JUNE 21 - LEVEL 01

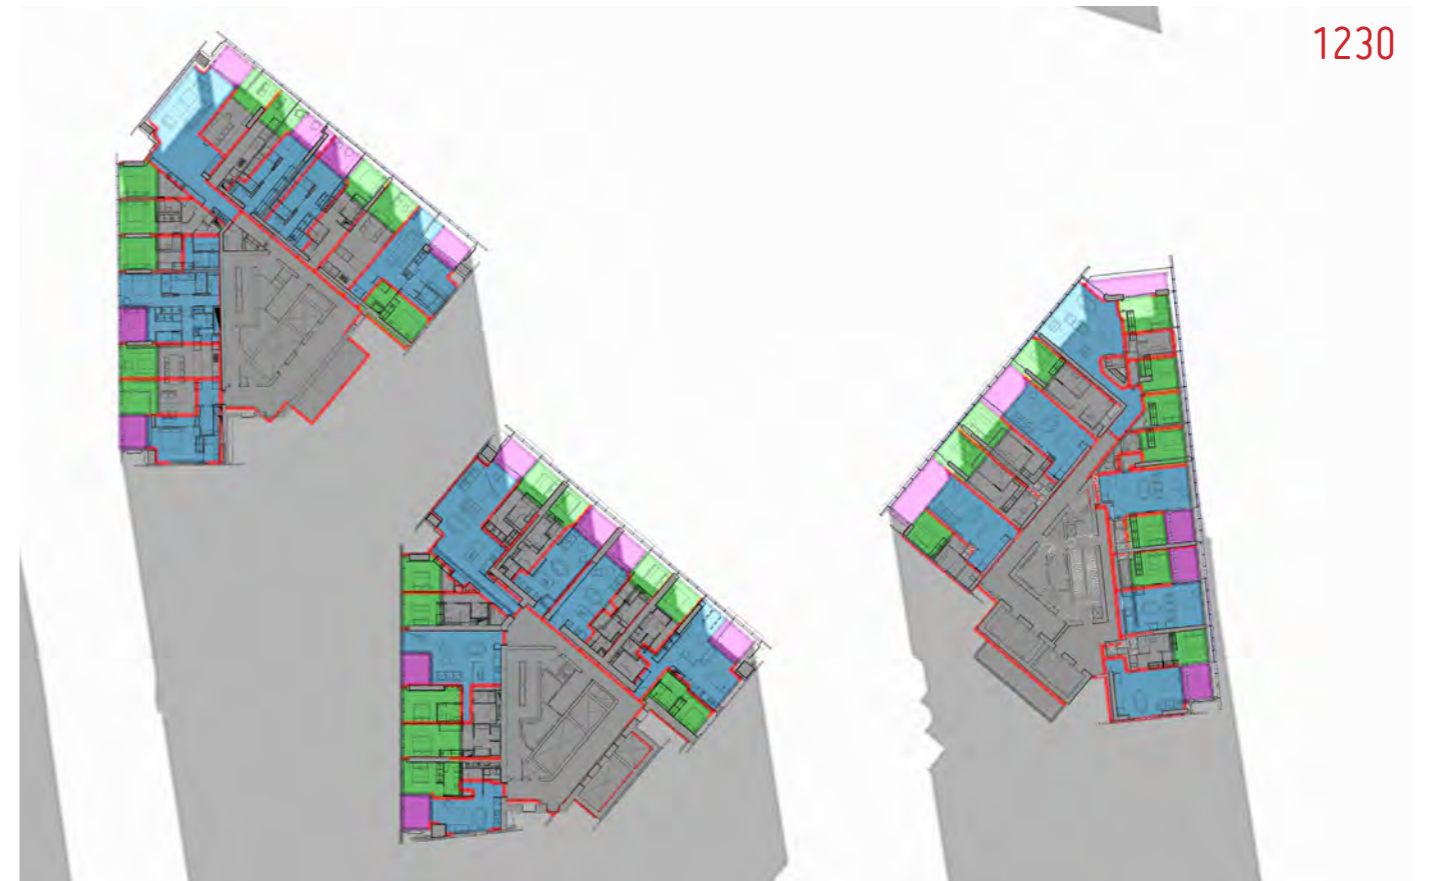
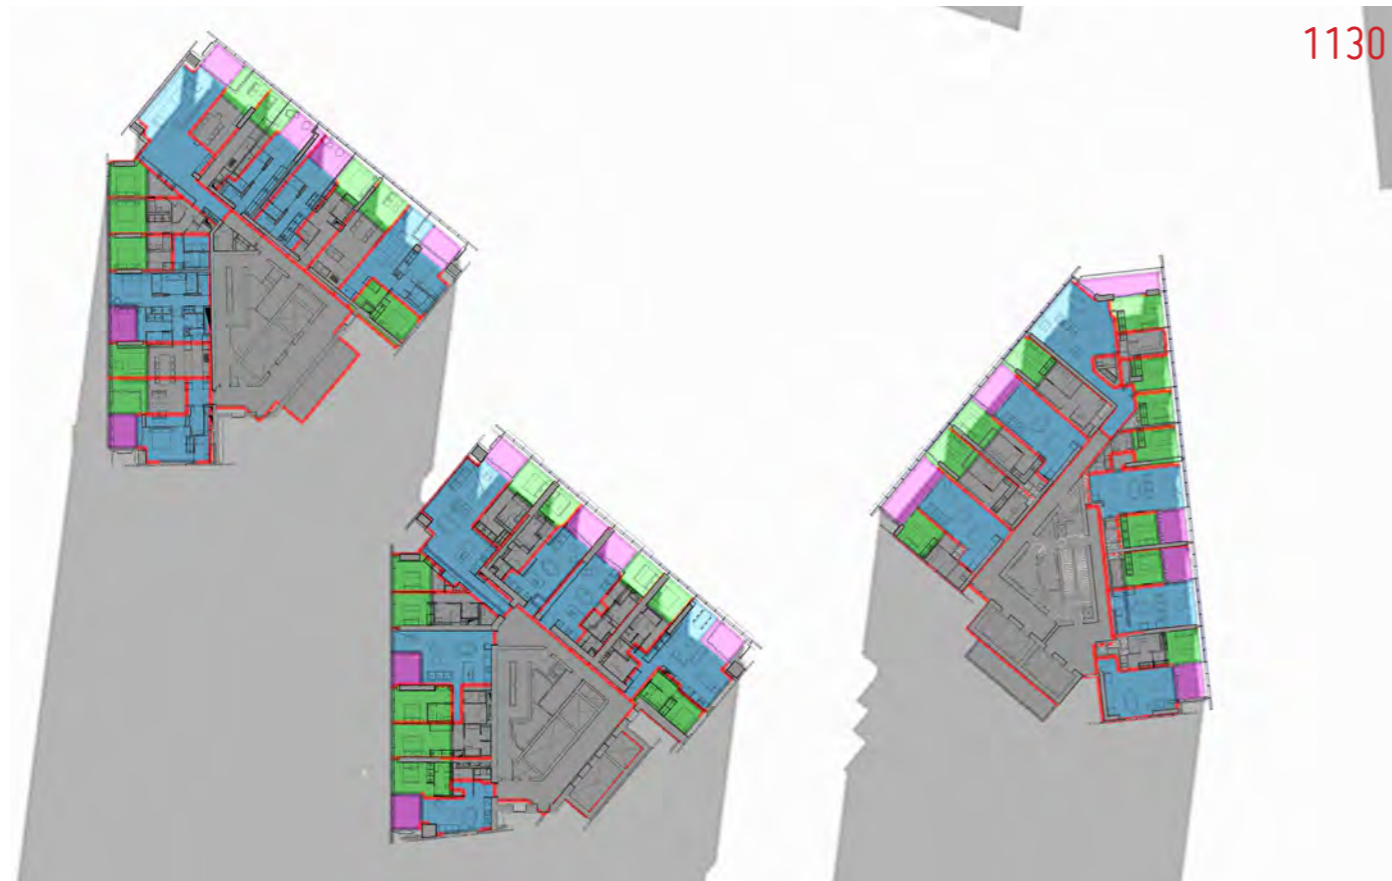
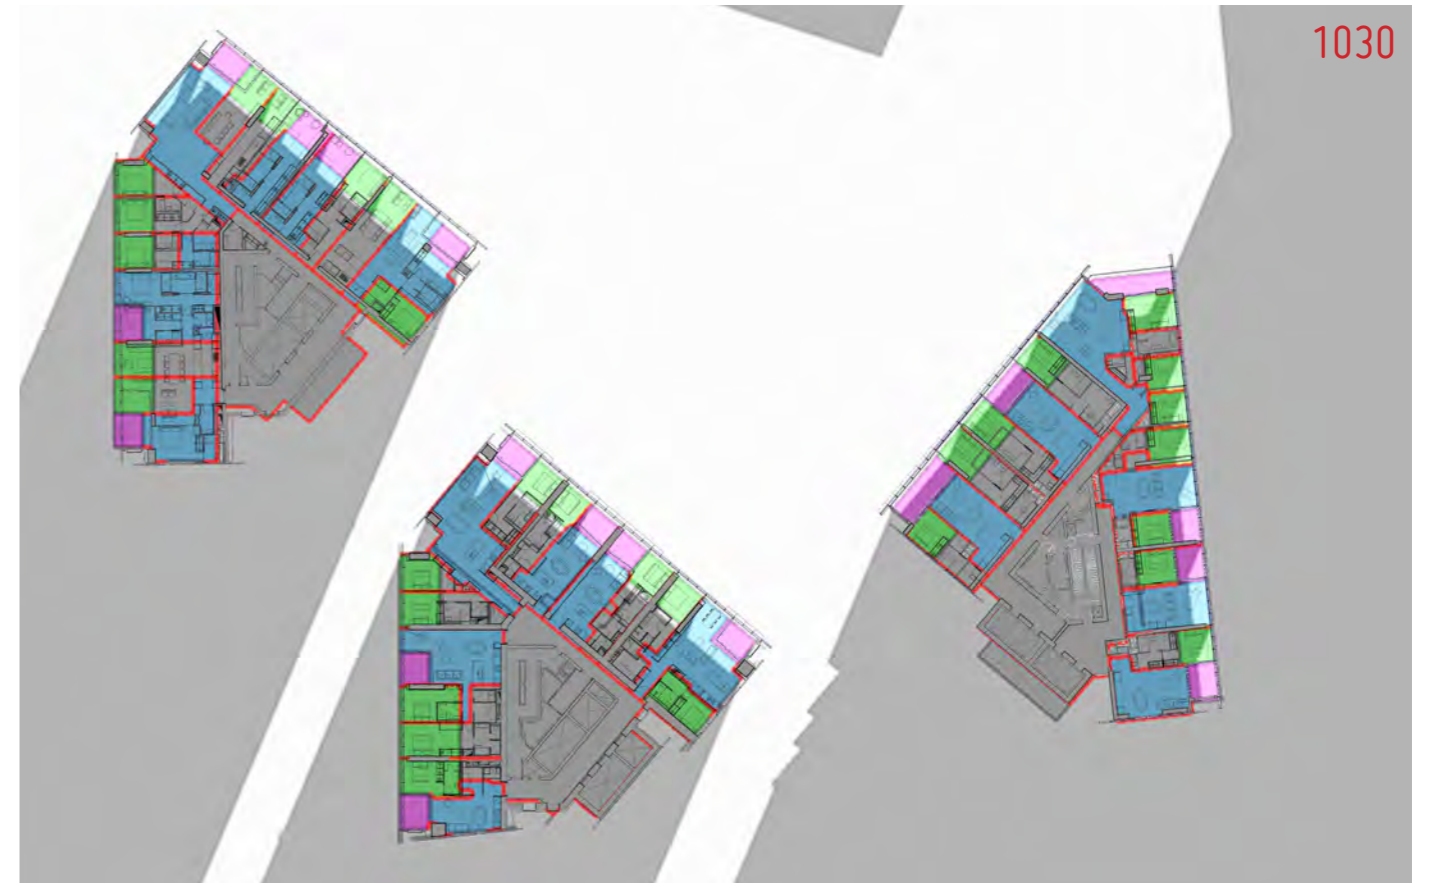
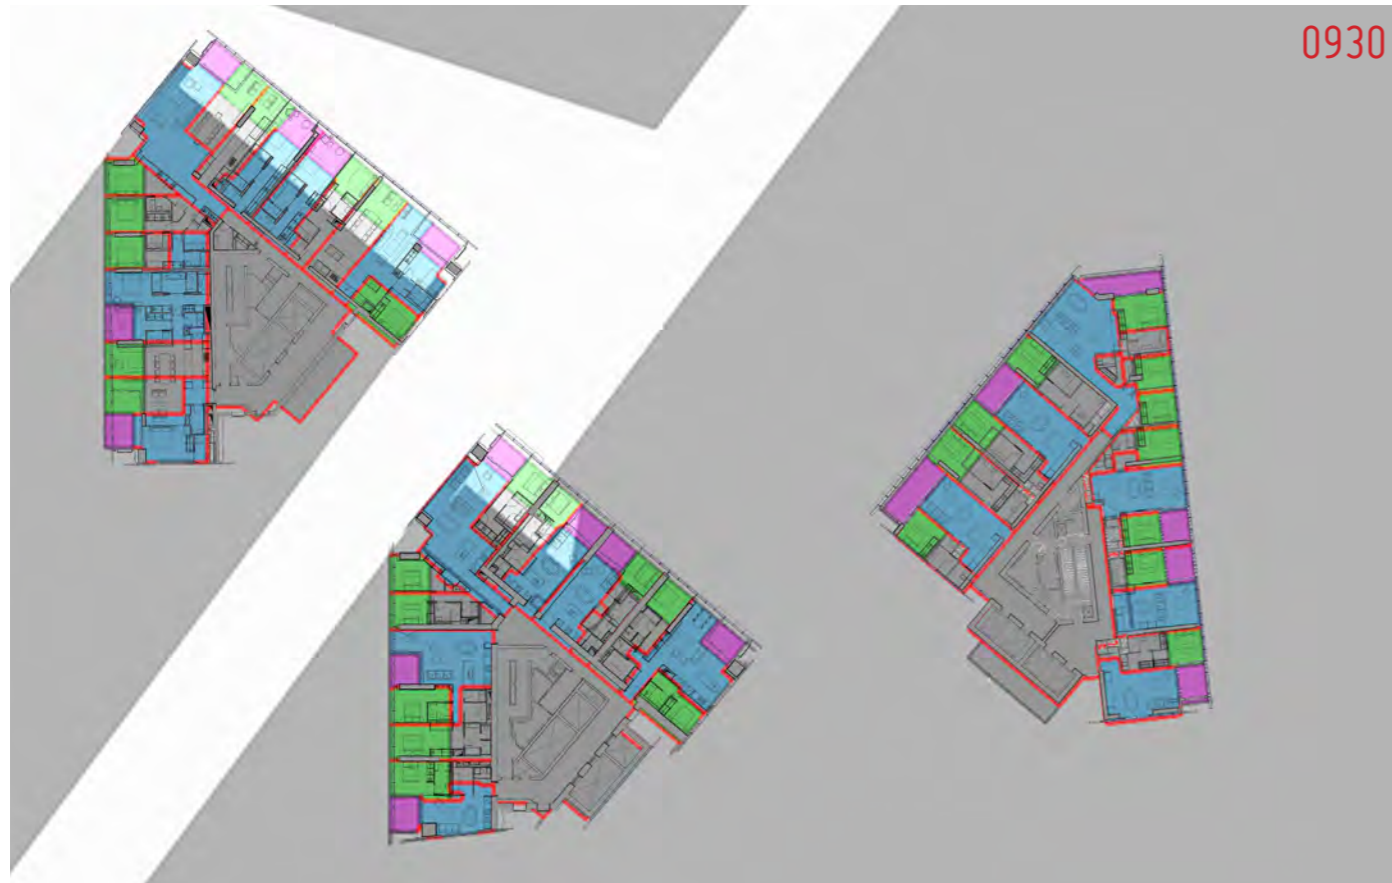
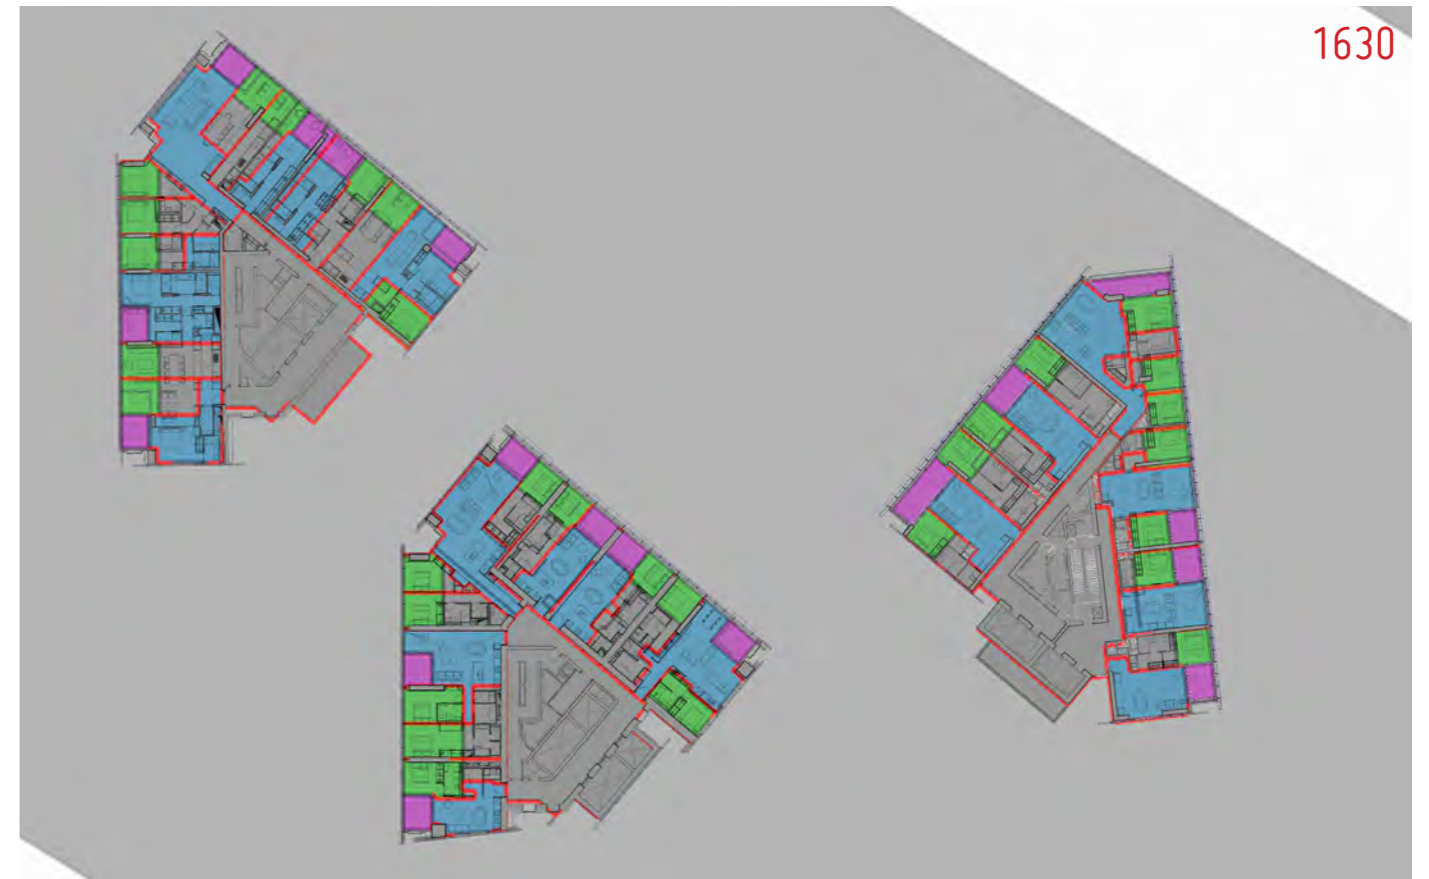
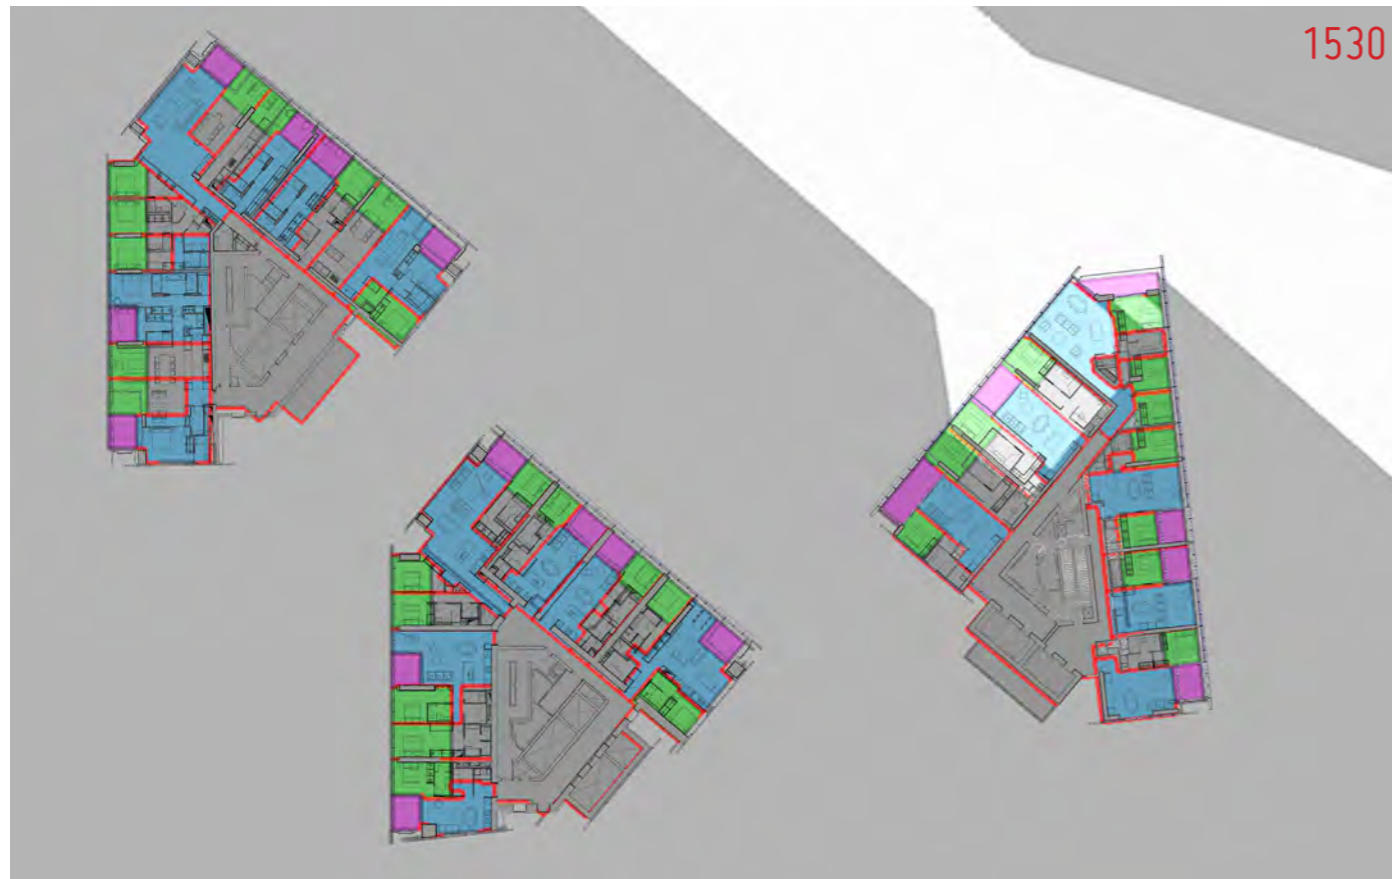
‘Further consideration should be given to the layout and configuration of units to improve opportunities for solar access for the development. In particular, the number of units receiving direct sunlight between 9am and 3pm in midwinter should be reviewed. In addition, the number of units within R4B that do not receive direct sunlight between 9am and 3pm in midwinter should also be reviewed.’

Solar access has been re-modelled with increased accuracy by introducing additional representative floors and apartments, beyond that of the initial modelling. A full solar report detailing the analysis of solar and daylight access across the individual buildings is included as part of the submission. The results of this report are briefly discussed here, and a schedule noting the number of hours each apartment receives is at Appendix A.

The total development achieves reasonable solar access for a site located within the density of the Sydney Metropolitan Area, with excellent daylight access due to the highly transparent façade and north-east and west orientation of all three buildings. Across the development, 66% of the apartments receive 2 or more hours of direct sunlight between 9am-3pm for living rooms and private open space during the winter solstice.

In addition, with the location of the buildings being near the western harbour edge, apartments will also receive sunlight at low solar altitudes. For this reason results have been presented for an extended time frame beyond 3pm. This approach is consistent with what was approved for Residential Buildings R8 and R9 at Barangaroo South. Sun perspective diagrams have been included to illustrate the duration of solar access the buildings receive. These diagrams are modelled from the perspective of the sun based on 21 June. Under the extended solar time-frame of 9am-4.45pm, 85% of apartments across the development receive 2 or more hours of direct sunlight to living rooms and private open space during the winter solstice.
